July 26, 2024

RE: Fowler Creek Guest Ranch (CU-23-00003)
Applicant: Fowler Creek Trails, LLC (Owner)

1. INTRODUCTION AND REQUESTED OUTCOME

FOWLER CREEK GUEST RANCH
EXHIBIT 12
EMERGENCY INGRESS AND EGRESS PLAN

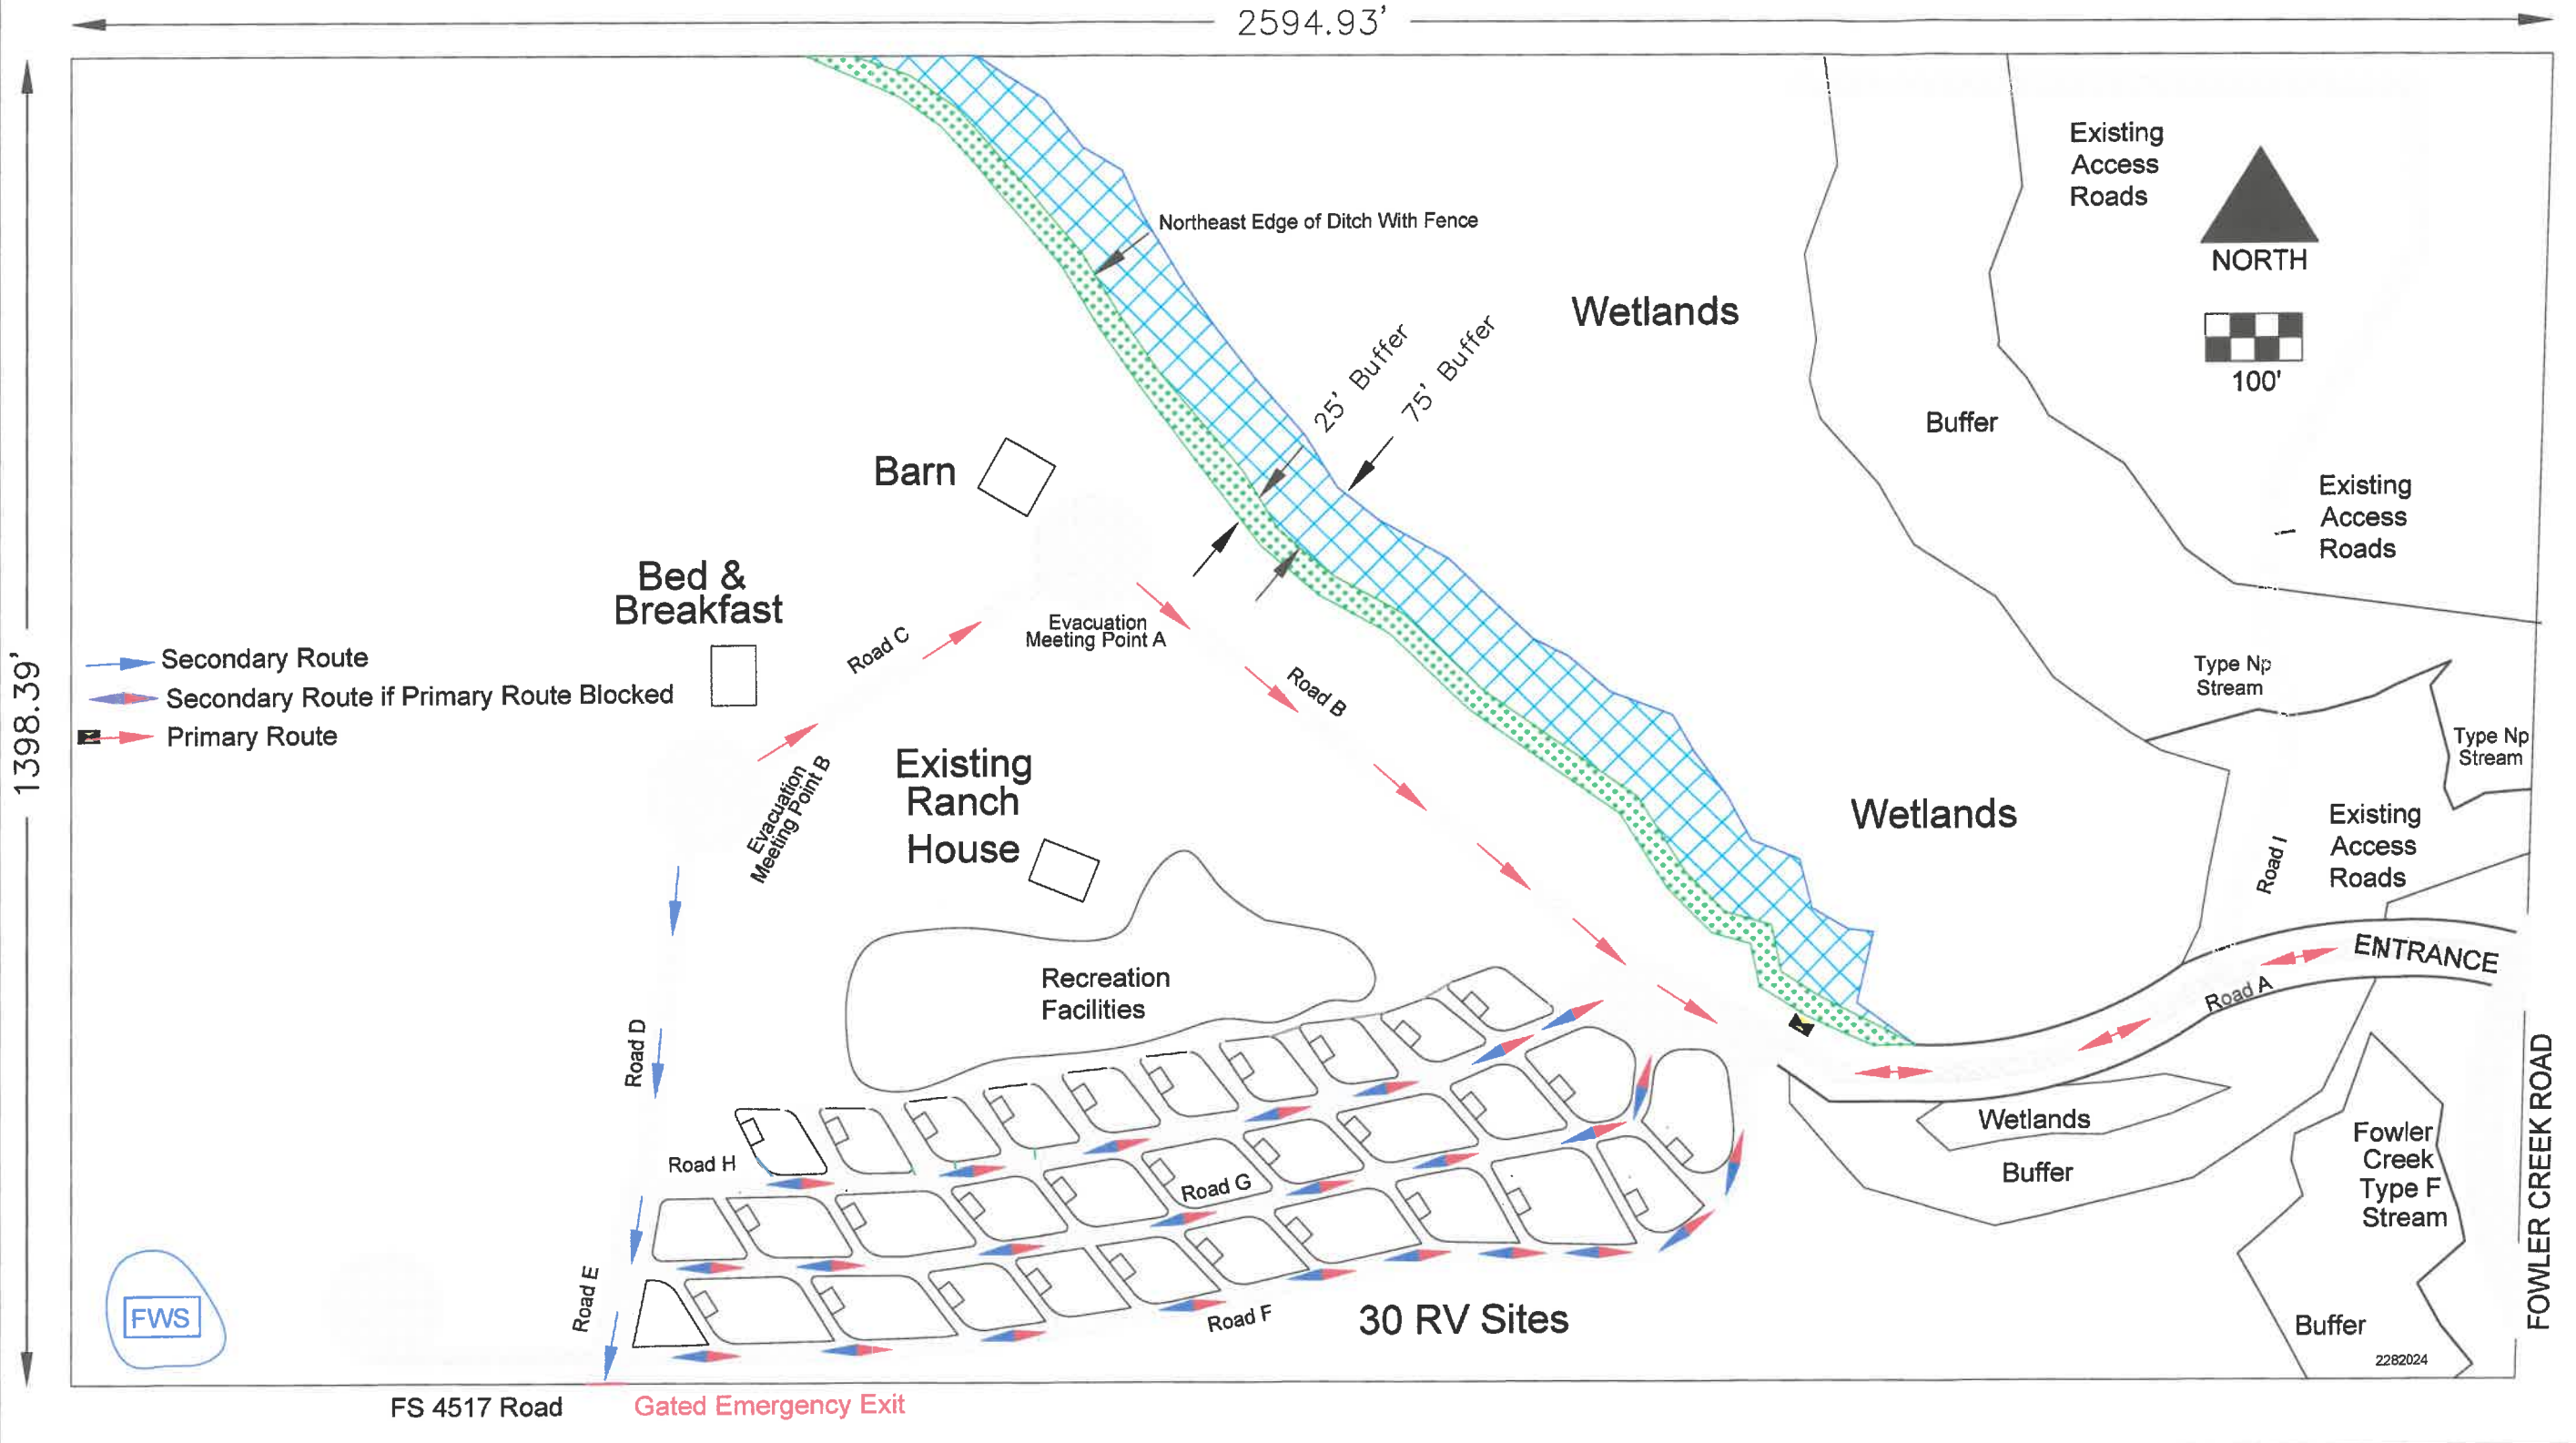
Another significant aspect of the proposal which is detrimental to the surrounding neighborhood centers on fire risk and evacuation in the event of wildfires. Simply put, the road infrastructure in this rural residential neighborhood is grossly insufficient to accommodate hundreds of vehicles in the event an evacuation becomes necessary. This acknowledgment is implicit in the July 19, 2024, comments from Fire District 7 which sets out road standards that must be met, including by Forest Service roads, and requires in particular a competent fire evacuation plan and provisions for gate access.

EXHIBIT 16 - SITE PLAN - FOWLER CREEK GUEST RANCH

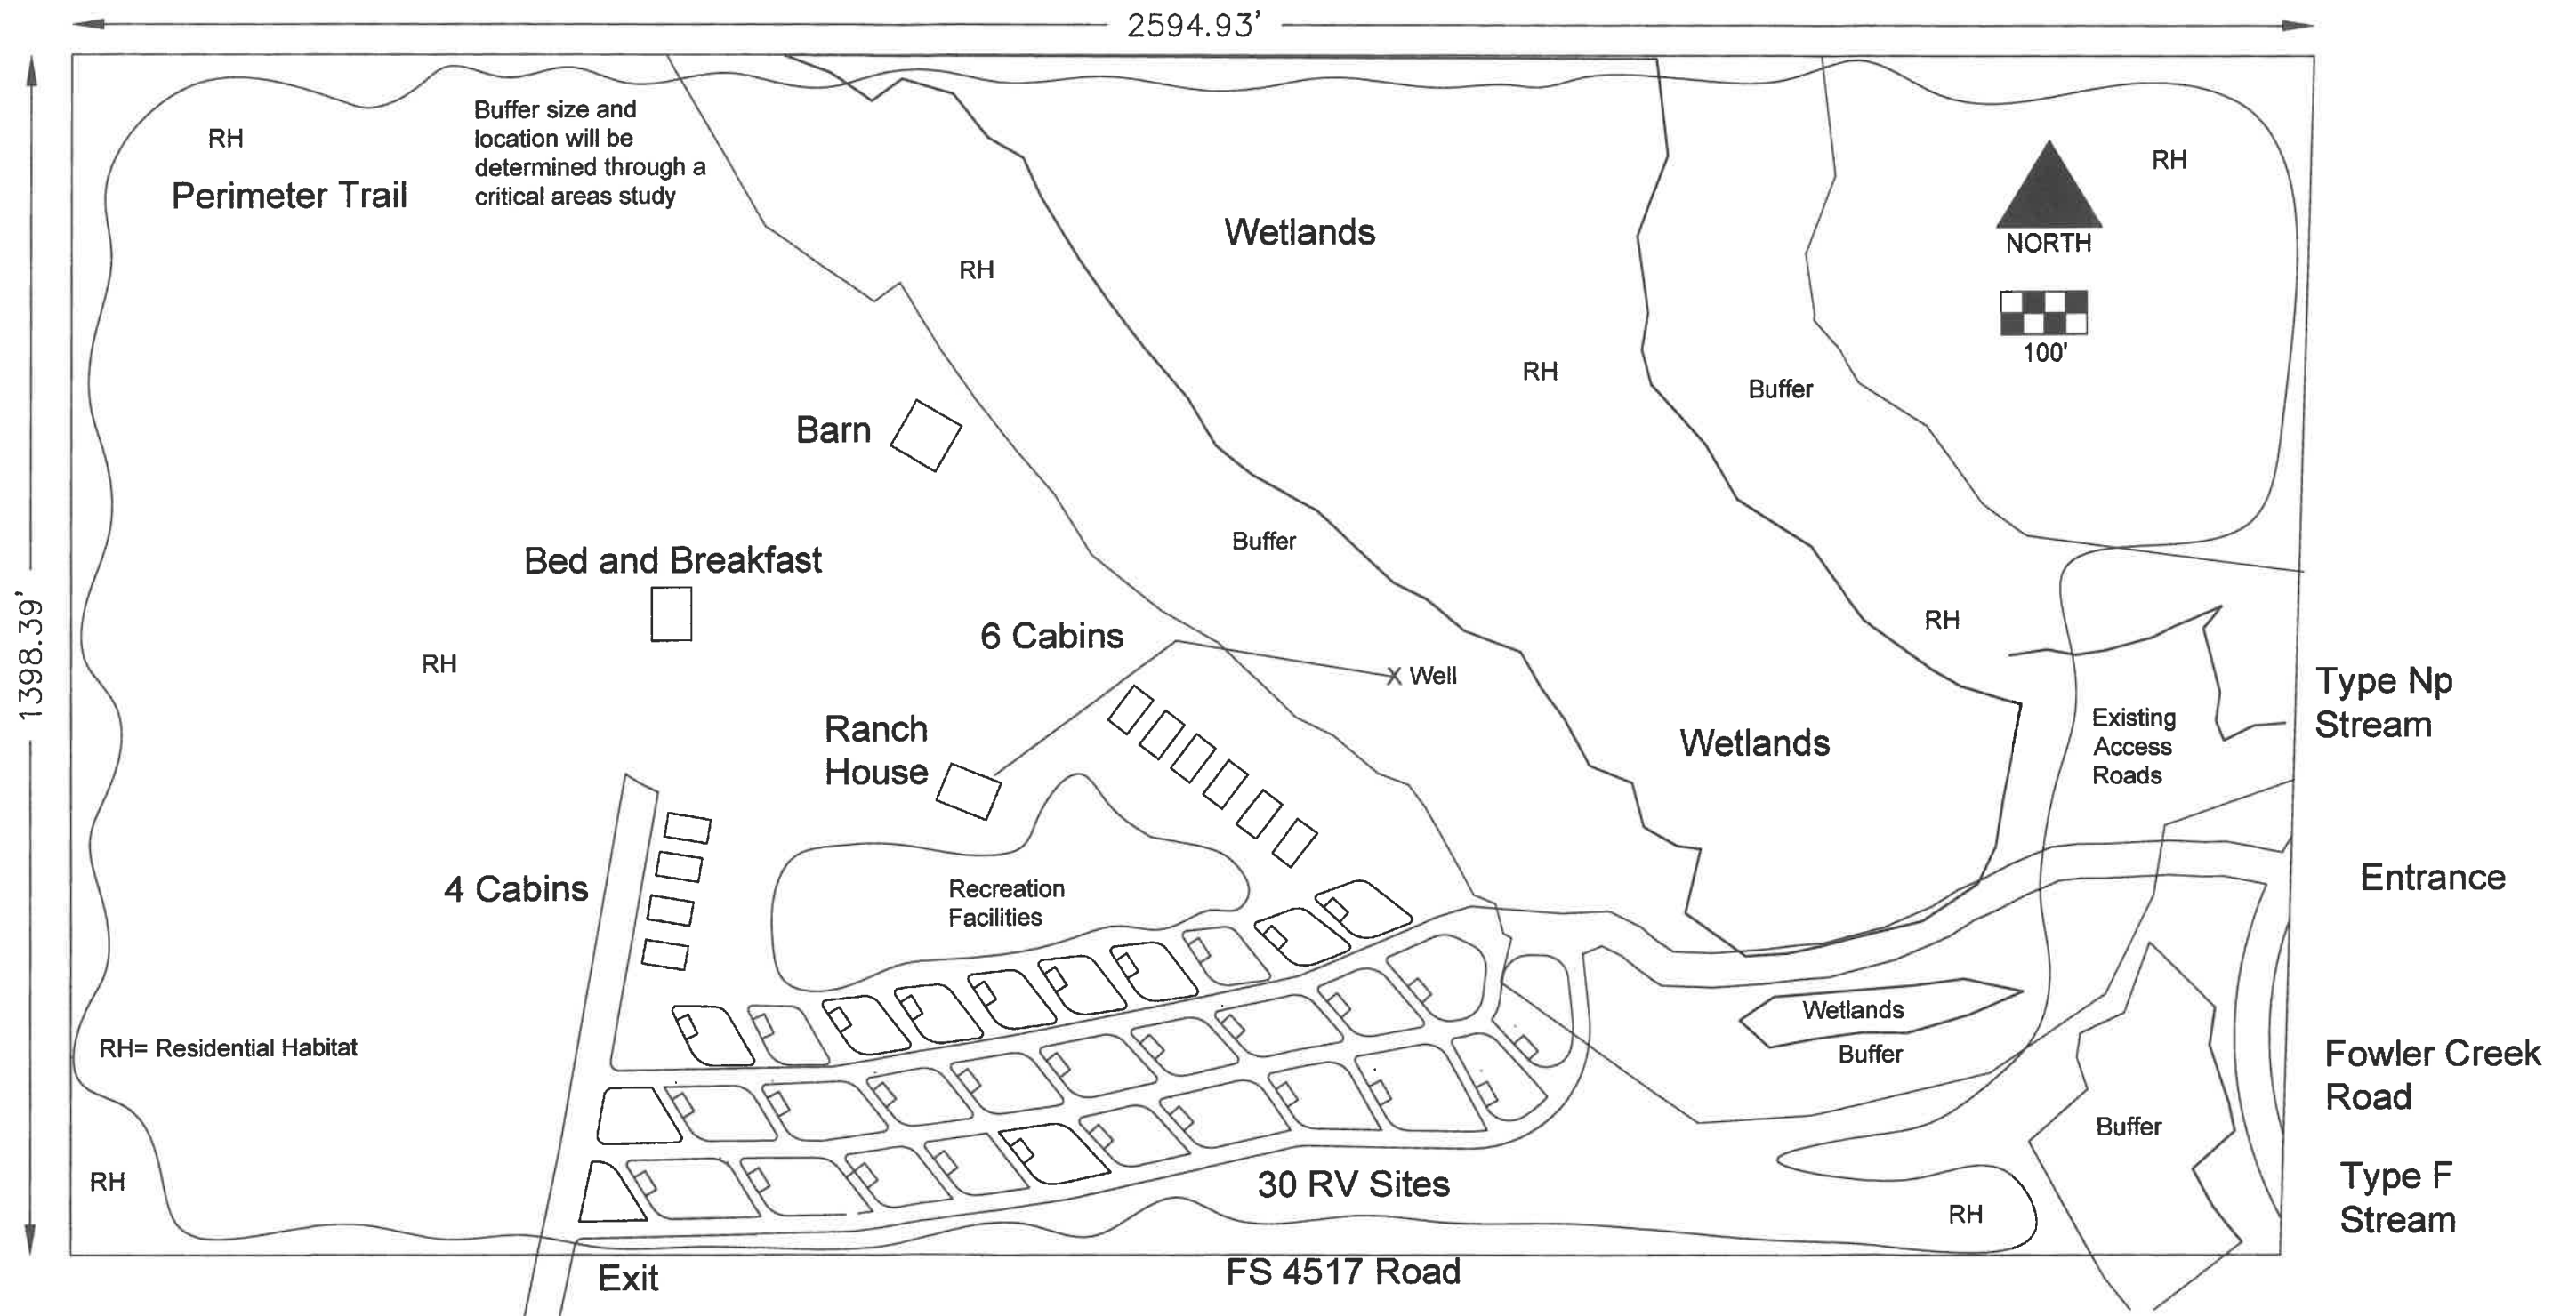
residential neighborhood.¹¹ They not only remain with the same intensity as proposed previously but remain in the same locations previously proposed -- literally abutting preexisting residential properties. The recreational vehicle park/campground that will serve a transient RV camper population is still in the same location immediately adjacent to residential properties and remains the same size, with capacity for 30 RVs per night. The so called “small-scale event center,” also remains unchanged with capacity for 200 guests and the Applicant has now made clear that the intent is to definitely hold more than 8 events per year. Applicant Response to Submitted Comments, Exhibit 20 at 14, fn. 6. The 7 bedroom “guest ranch” and 5 bedroom “bed and breakfast” remain unchanged as well, as does the multi-faceted store.

The proposal is located in very close proximity to residential development. The southwest portion of the proposal is immediately adjacent to residential properties.¹³ The southwest portion of the proposal is the area that includes the campground/recreational vehicle park, fire water storage, emergency access road and turnaround area.¹⁴

As a threshold matter, a campground/RV park is detrimental to the surrounding rural residential neighborhood and incompatible with it, particularly when located in such close proximity and stacked on top of the other elements of the proposal which are themselves intensive. The 30 RV sites will accommodate RVs along with ORVs, snowmobiles and other vehicles brought in tow as transient RV campers come and go daily. The traffic, noise, light and fire hazards posed by the campground/RV park cannot be overstated. Although the Applicant has purported to eliminate personal fire pits, fire pits will remain; individuals will also smoke, barbeque, etc. RV campers, who could total up to 120 people at a time,¹⁵ will obviously congregate day and night

- 4. If the 30 RV use nonetheless is not eliminated in its entirety, then, at a minimum it should be reduced to five parking spots and re-located to minimize impacts and provide a buffer for existing residential properties. *See KCC 17.60A.020.***

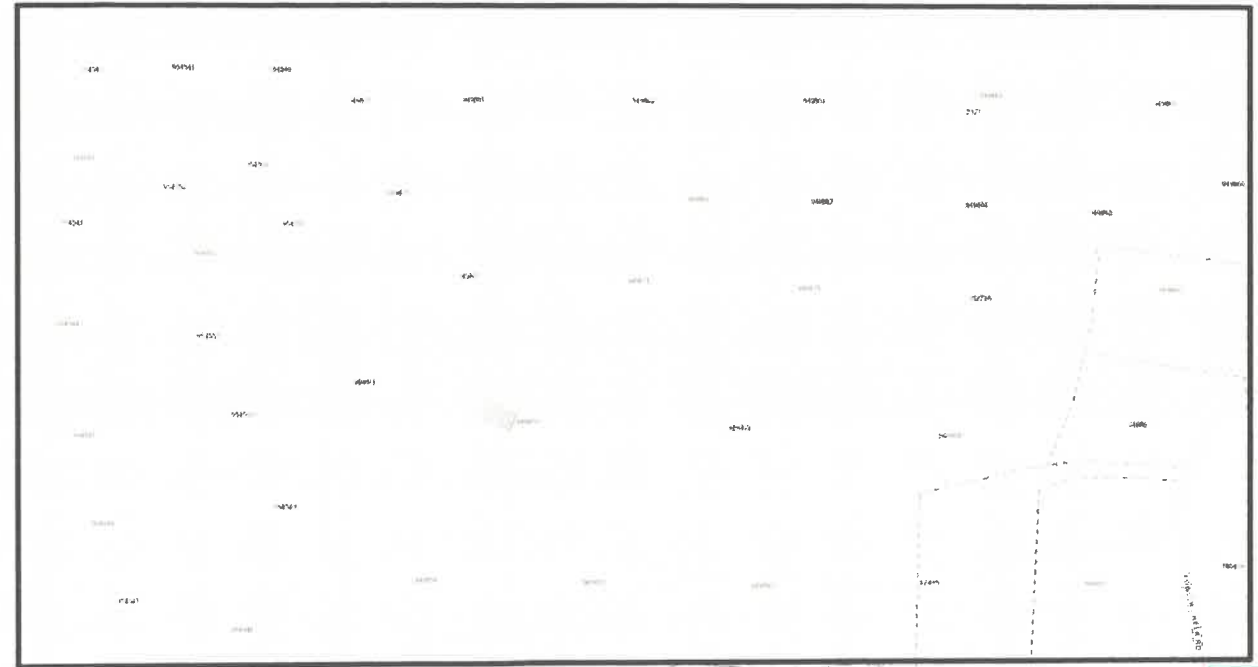
¹³ Applicant has provided a document titled “Adjacent Surrounding Properties Review” which purports to identify distances from certain locations on nearby residential properties and specific locations selected by the Applicant within the proposal. Applicant Response to Submitted Comments, Exhibit 16. It is not clear how exactly the measurements were made and/or from what points precisely. However, what it is clear is that, by any metric, all of the residential properties are very close to the proposal. Indeed, some share boundary lines with the proposal. The distances to/from various points provided by Applicant are thus misleading.
